WEST SUSSEX COUNTY COUNCIL CONSULTATION

TO:	Arun District Council FAO: Anita Gardner
FROM:	WSCC - Highways Authority
DATE:	24 May 2019
LOCATION:	Sparks Yard Lifestyle Store Sparks Yard 18 Tarrant Street Arundel BN18 9DJ
SUBJECT:	AB/48/19/PL Change of uses to form an upper floors single, four bedroomed residential unit (use class C3a) & a ground floor commercial unit (use classes A1, A2 and B1a), together with all associated works. This application affects the character & appearance of the Arundel Conservation Area.
DATE OF SITE VISIT:	23/05/2019 18:00 - 19:00
RECOMMENDATION:	Advice
S106 CONTRIBUTION TOTAL:

SITE PLAN

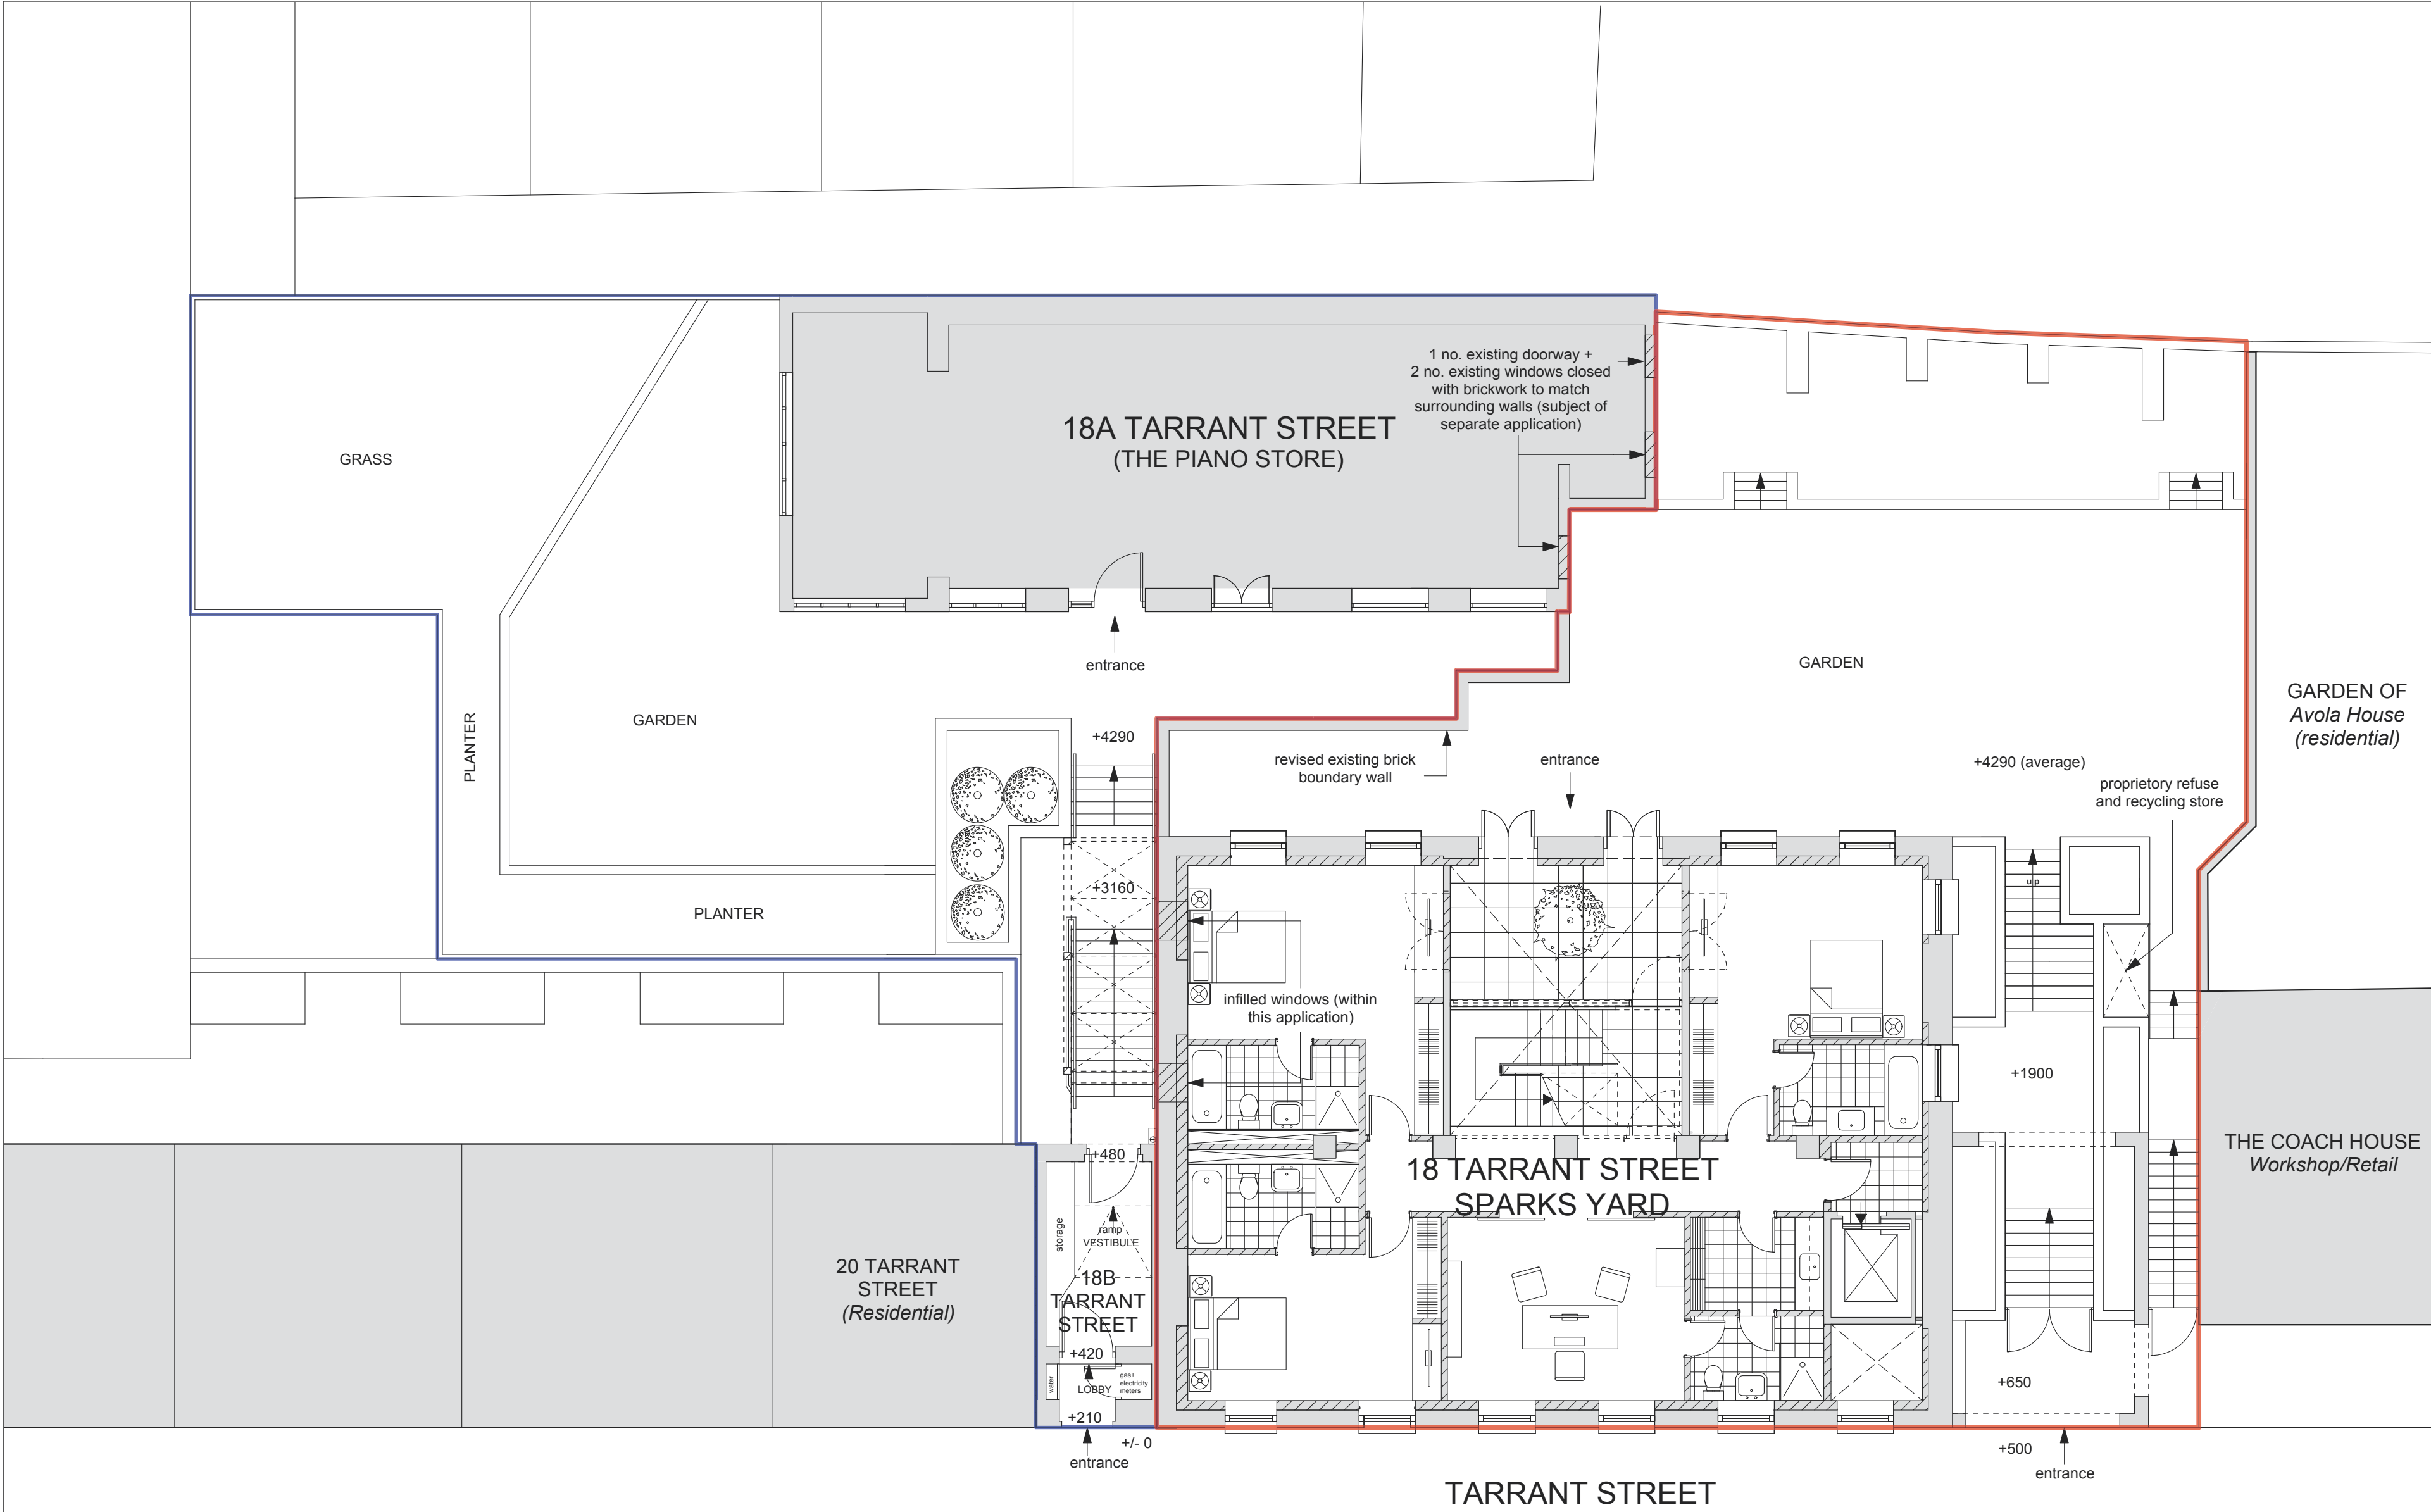
The site is located in a sustainable location within walking and cycling distance to a range of public services, amenities and employment options. Bus and rail links provide a realistic travel opportunity for longer trips. As a result, the Local Highways Authority (LHA) would like to see cycle storage space being implemented on plans, this can be secured via condition.

No part of the development shall be first occupied until covered and secure cycle parking spaces have been provided in accordance with plans and details to be submitted to and approved by the Local Planning Authority.
